Memo

From: Holly Myers, Environmental Health Supervisor

RE: BL-14-00023 Darling II

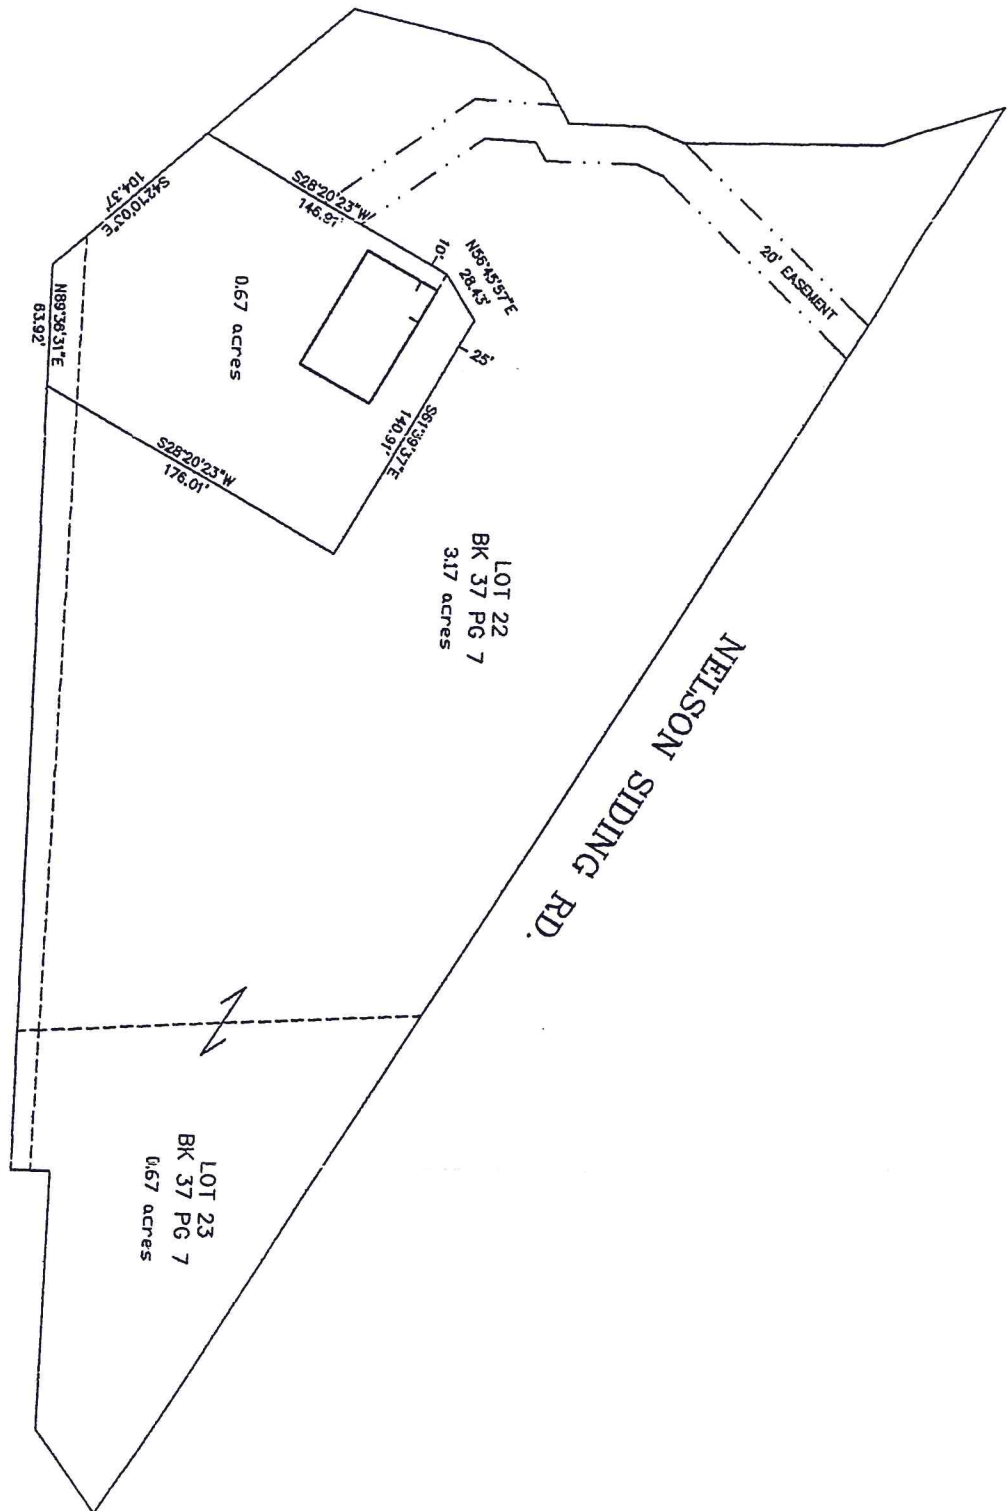
- A shared well users agreement is required if the residence located within the new boundary intends to continue to use the existing water source located outside of the new boundary line.
